Portishead Branch Line (MetroWest Phase 1)

TR040011

9.33 ExA.WQ2R.D5.V1 – Applicant's responses to the Examining Authority's
Written Questions ExQ2

Responses to ExA Questions
Applicant's Responses to the Examining Authority's EXQ2 Round of Written Questions

2.39 to 2.40 - Wessex Water Compound and Portbury Hundred Construction Compound

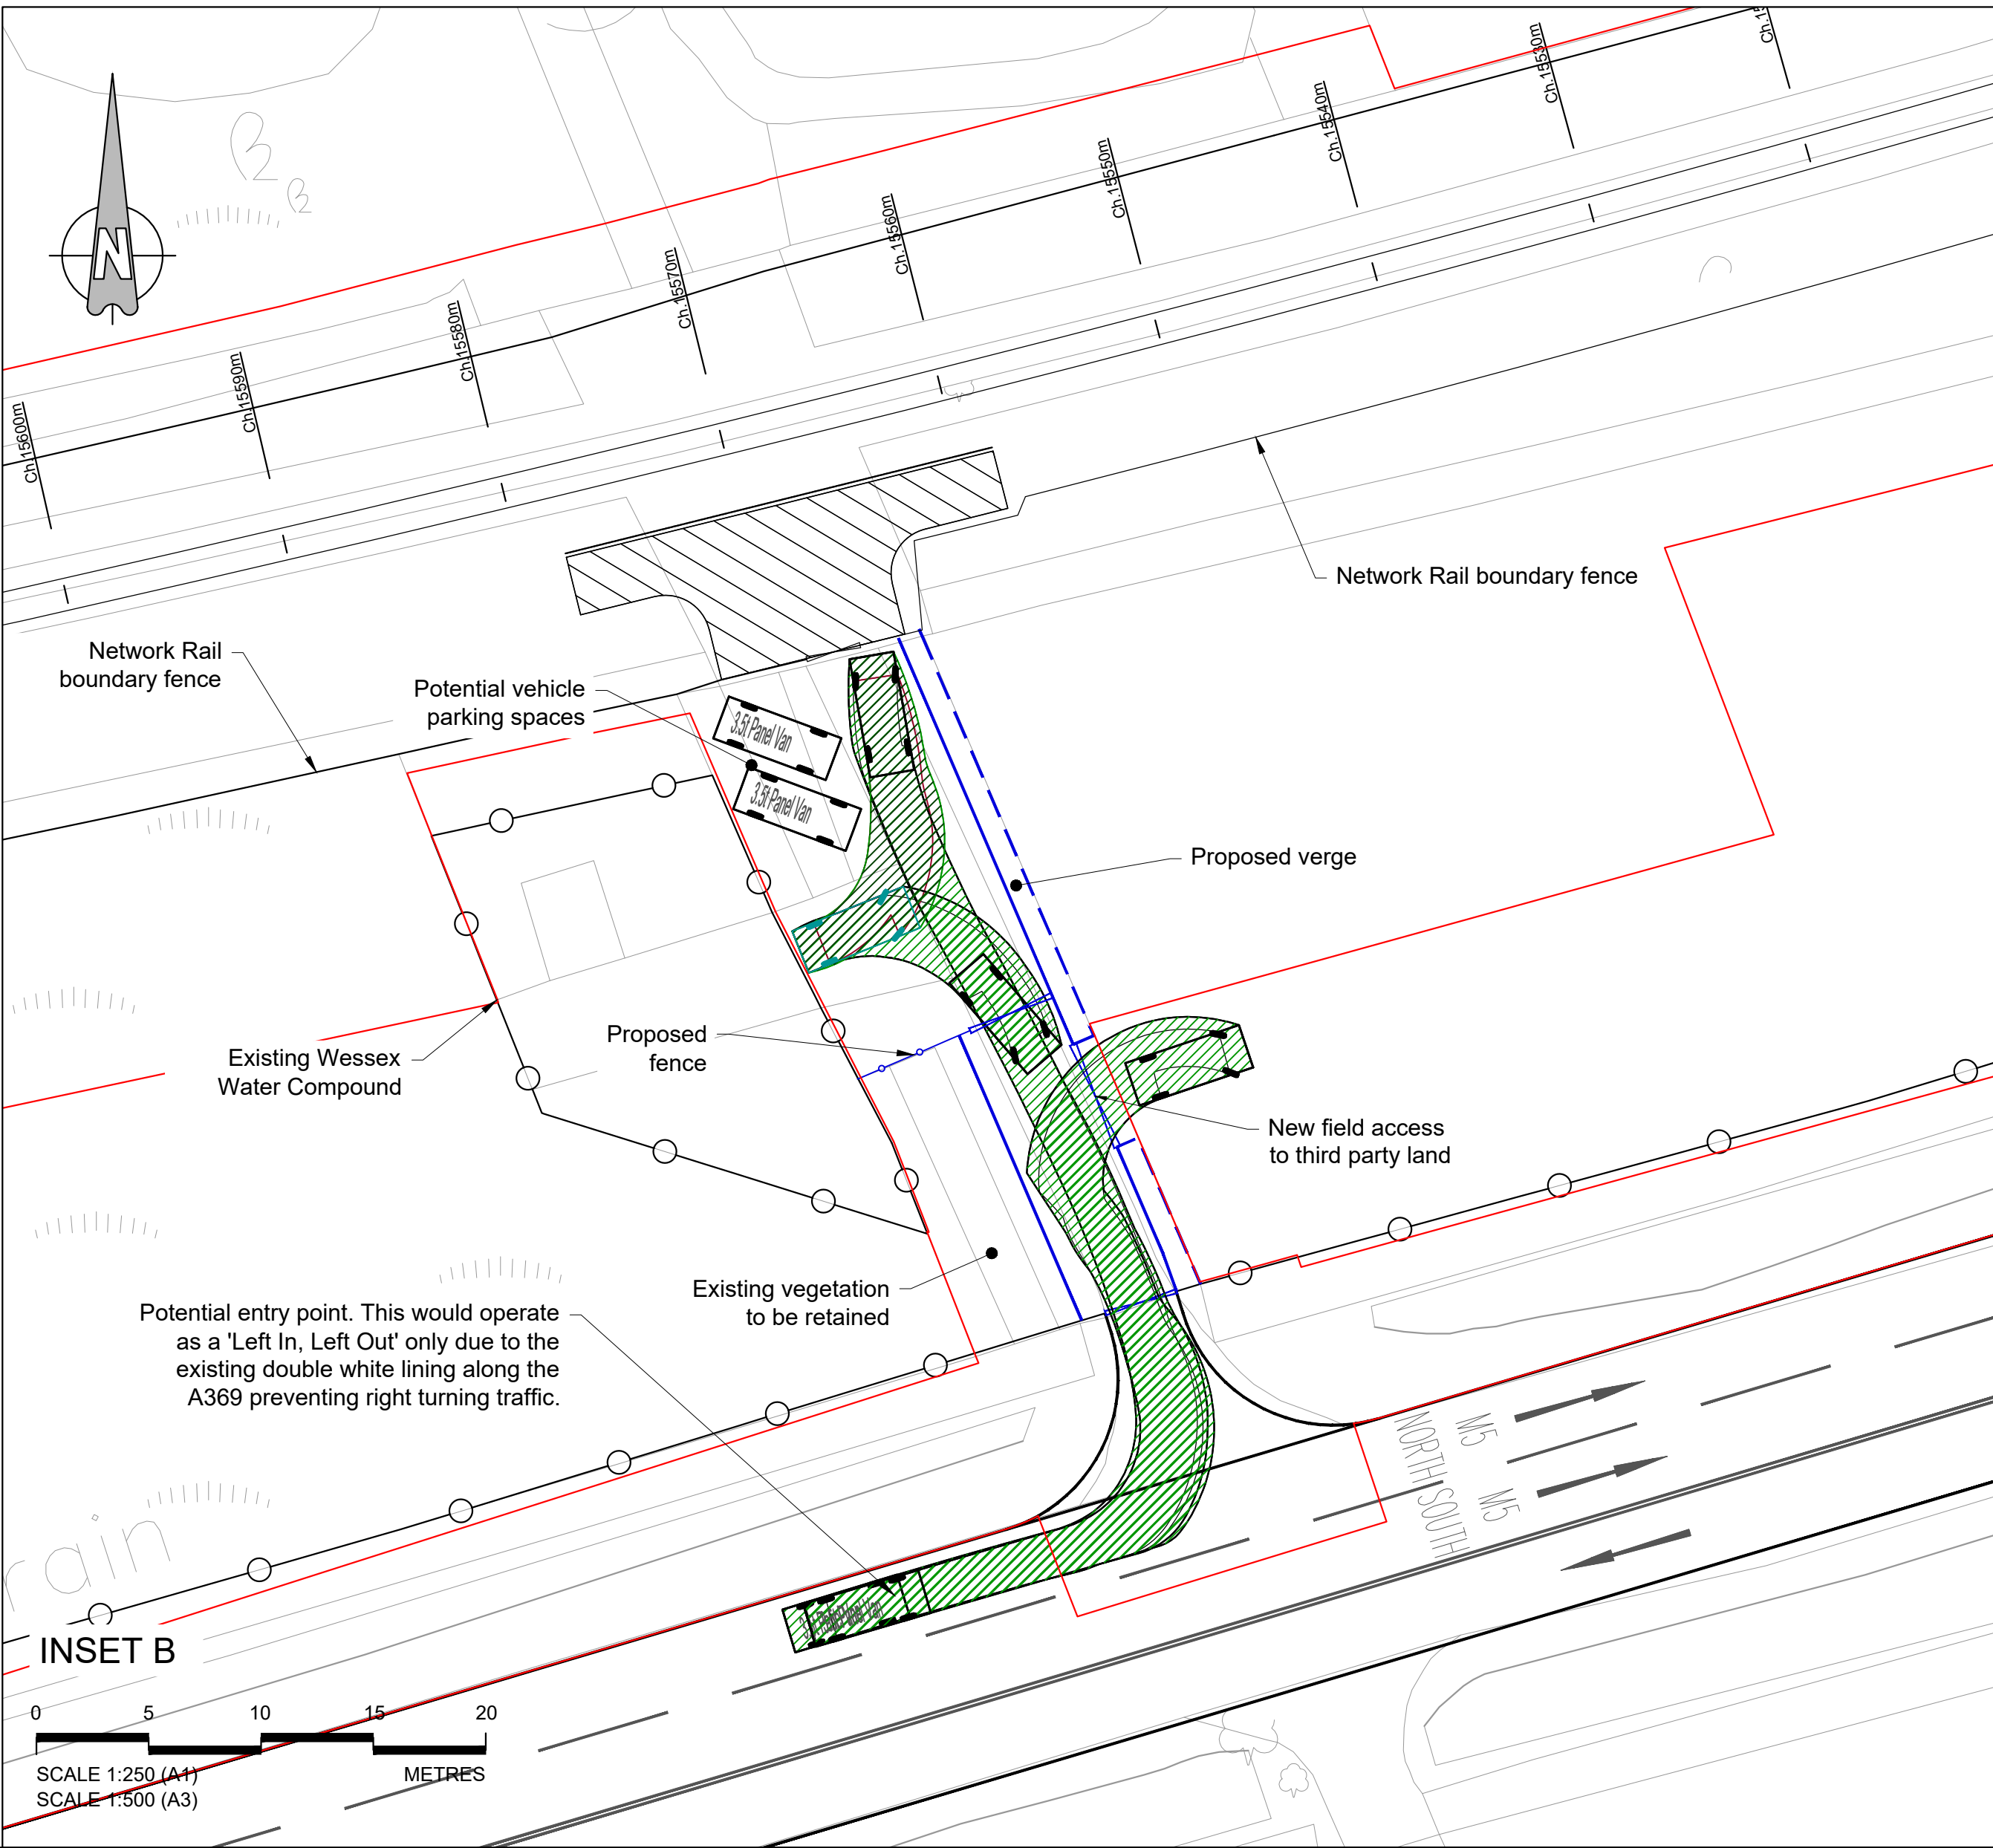
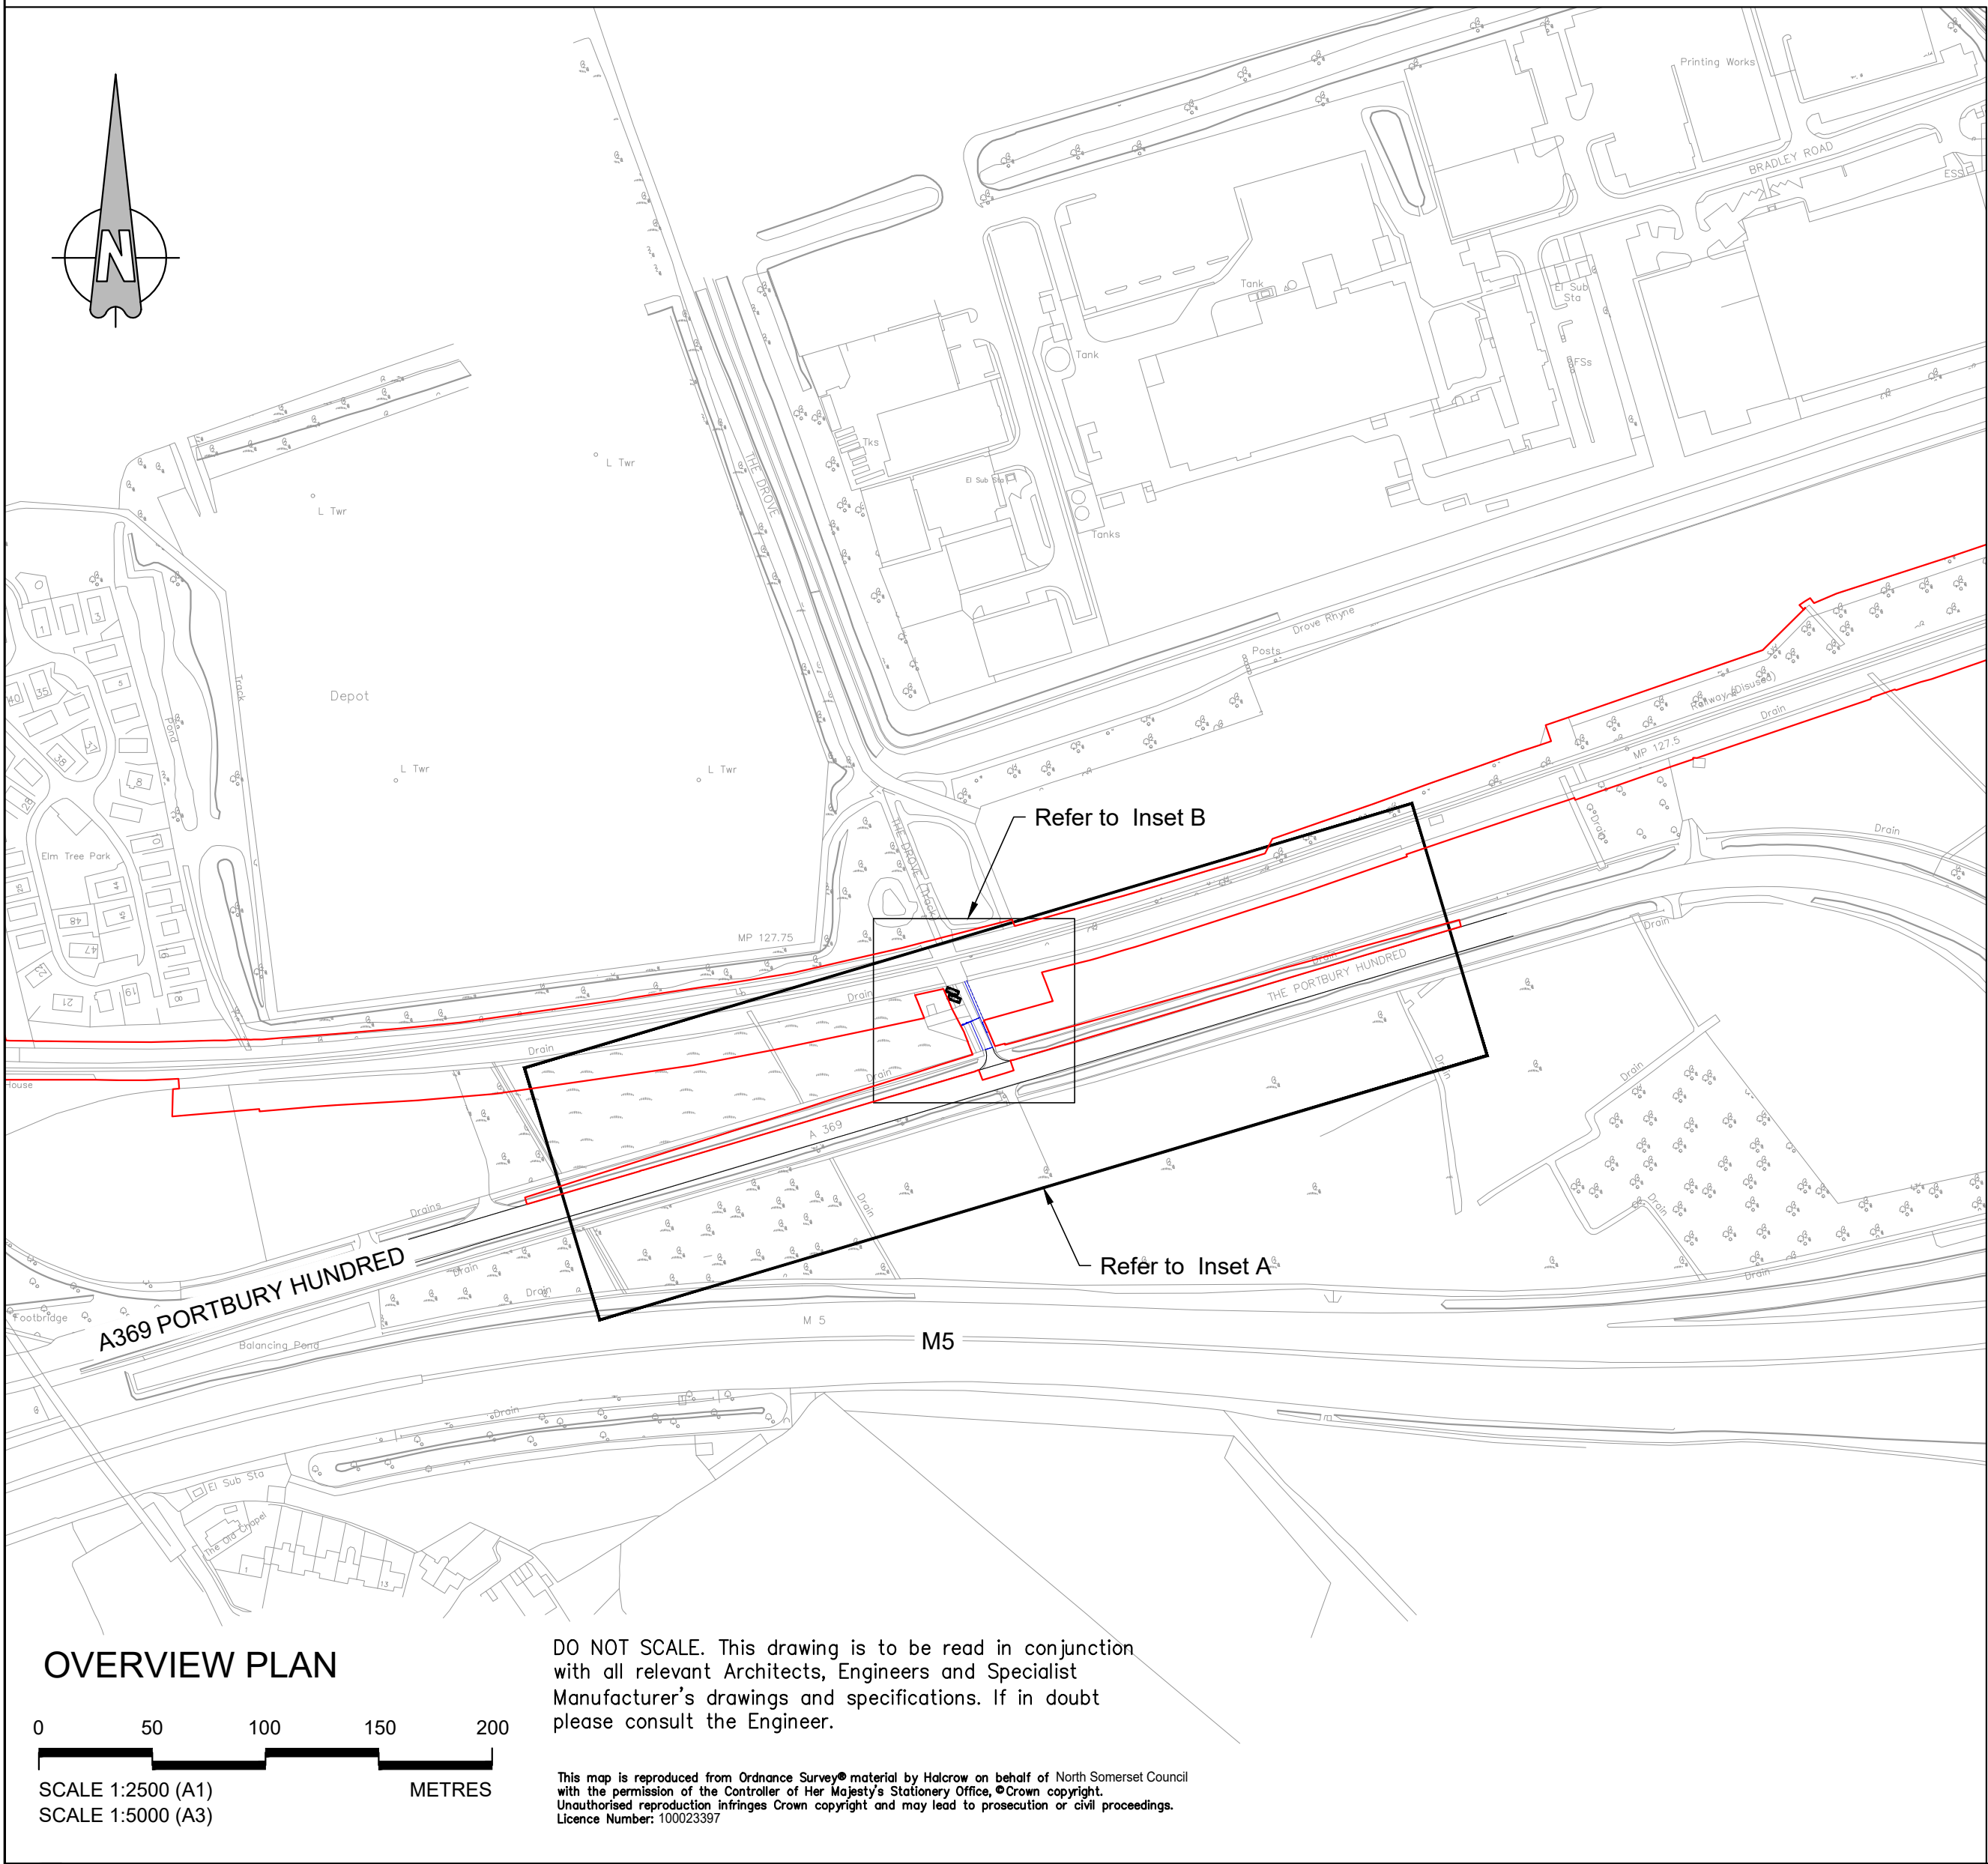
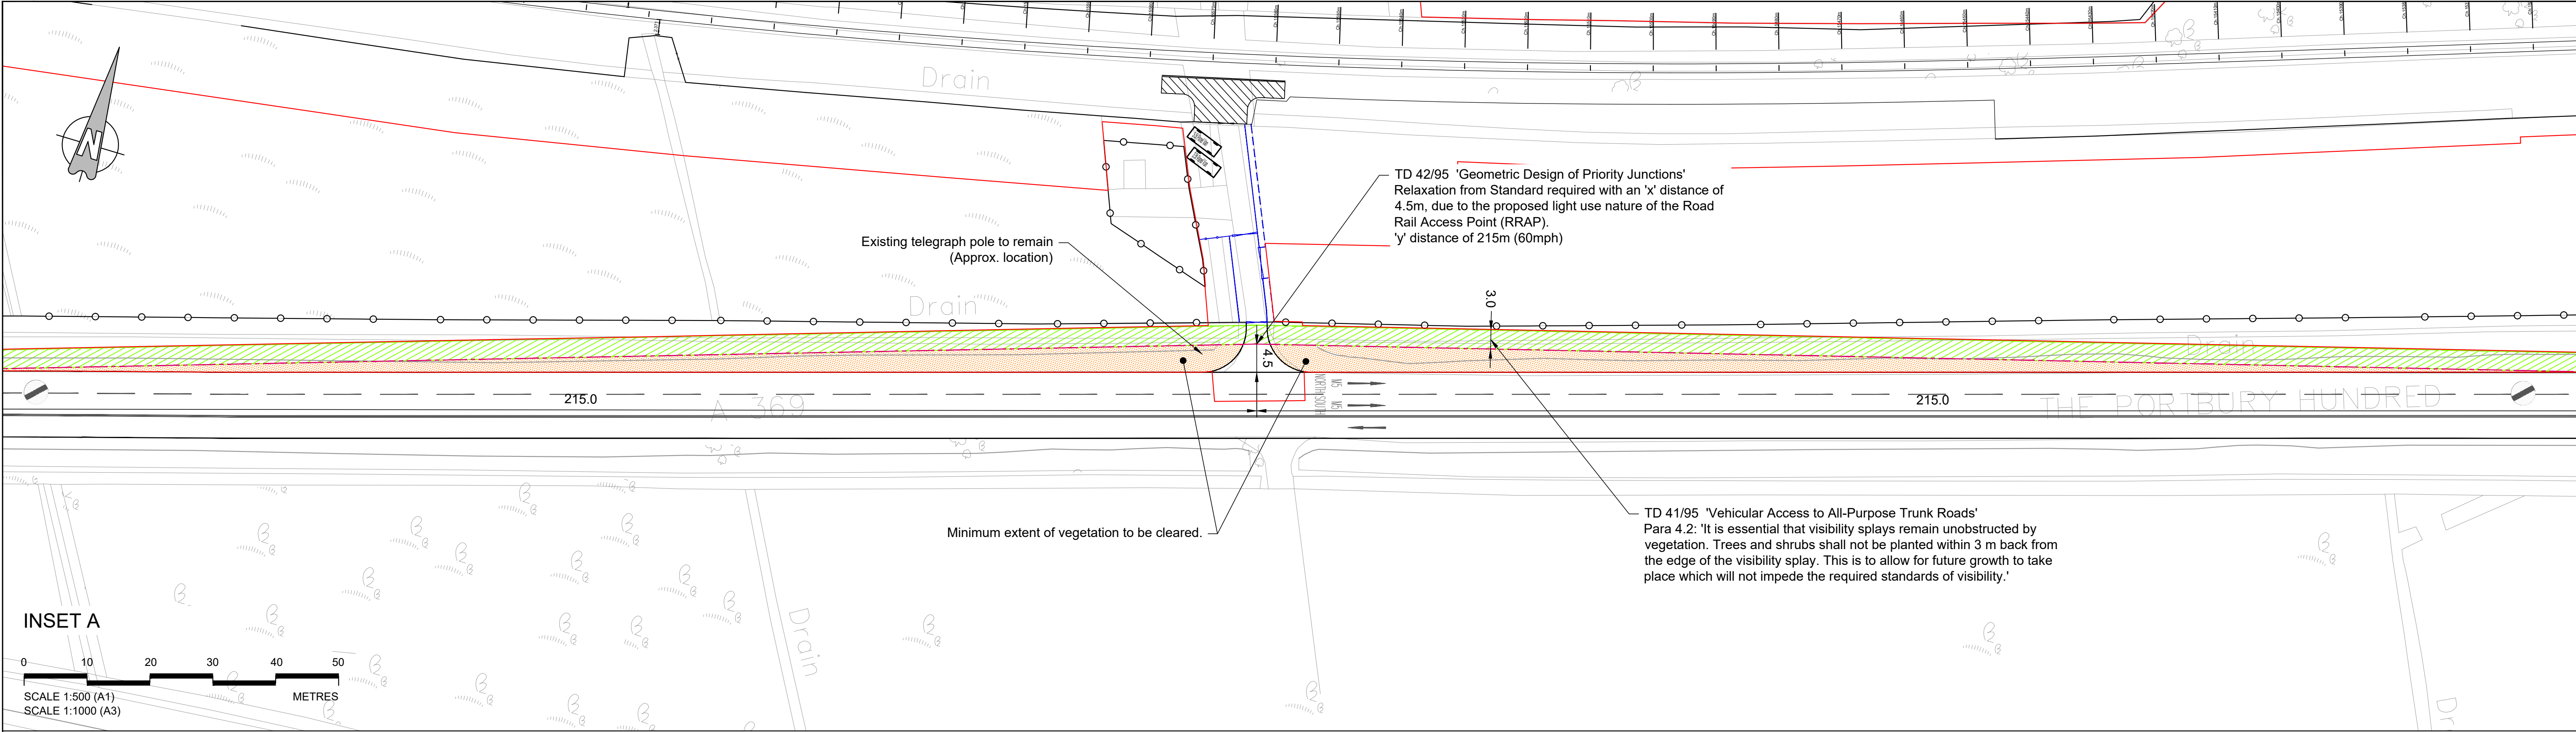
| ExQ2 | Question to: | Question | Current response |
|--------|---|--|---|
| CI.2.2 | <p><i>Access at Portbury Hundred</i> The Applicant</p> | <p>Permanent access into Portbury Hundred following use of land as a temporary construction compound is required as an alternative farm access following closure of a crossing. However, the scale of the junction</p> | <p>i) The A369 Portbury Hundred is a relatively high-speed road and has been designed to allow vehicles to leave the highway completely before stopping at the gate, and with sufficient space so that they do not cross onto the opposite side of the carriageway. Similarly,</p> |

| ExQ2 | Question to: | Question | Current response |
|--------|--|---|---|
| | | |  <p data-bbox="1308 651 2114 754">The access arrangement has been agreed with NSC Highways for the planned uses (during construction and farm access).</p> <p data-bbox="1308 799 2114 1086">ii) The junction will form the sole access for the landowner. A gate will be installed to prevent public access onto the landowner's land. There are a large number of similar agricultural access throughout North Somerset. As with these similar accesses should anyone other than the landowner block the access, then the landowner or the NSC Highways should contact the Police.</p> |
